Address: 27, Birklands Road, Huddersfield, Hd2 2pf

Application number: 2025/93556	
What is the application for?:	Erection of single storey extension and formation of patio
Address of the site or building:	29, Birklands Road, Cowcliffe, Huddersfield, HD2 2PF
Postcode:	HD2 2PF

REAR EXTENSION AND PATIO AT
29 BIRKSLAND ROAD
COWCLIFFE
HUDDERSFIELD
HD2 2PF

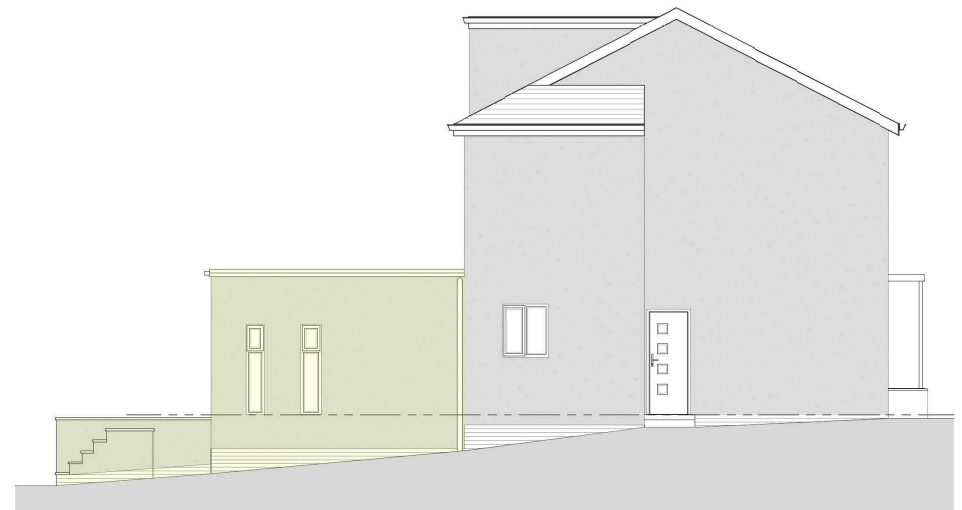
Type of comment: An objection	
Do you wish your comments to be published on the website anonymously?	No
I'm just wanting confirmation that the extensions windows that overlook our back garden will be obscured glass as per the previous application? Also, the newly raised patio area, that exceeds 1 meter in height, is this considered appropriate and not a breach of our privacy as it's now level with the top of the boundary fence and our garden now feels overlooked? Thank you for your time.
